Application No: K/47/21/HH
Site Address: 2 Gorse View Peak Lane Kingston BN16 1RW
Description of works: Two storey front and side extension with front balcony, part 1/2 storey rear extension and detached garage, including demolition of attached garage and extension

Thank you for your internet representation made on 13th November 2021 which has been recorded as no objection with the comments as follows:

Proposed Front Elevation
Scale 1 : 100

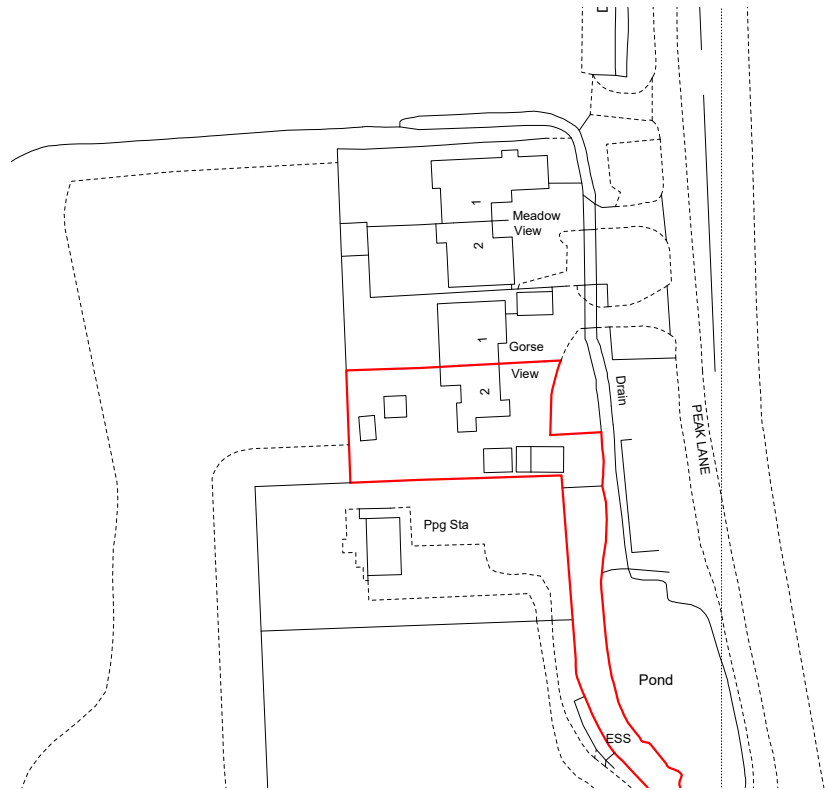
- there is no undue overlooking from the balcony that would affect the privacy of the neighbouring property
- the proposed frontage does not overly dominate the appearance of the dwelling or the neighbourhood
- materials to be used are suitable for the character of the area (per the condition relating to materials attached to planning application K/20/21/HH), and
- there is a condition relating to the use of the garage (per the condition relating to materials attached to planning application K/20/21/HH)
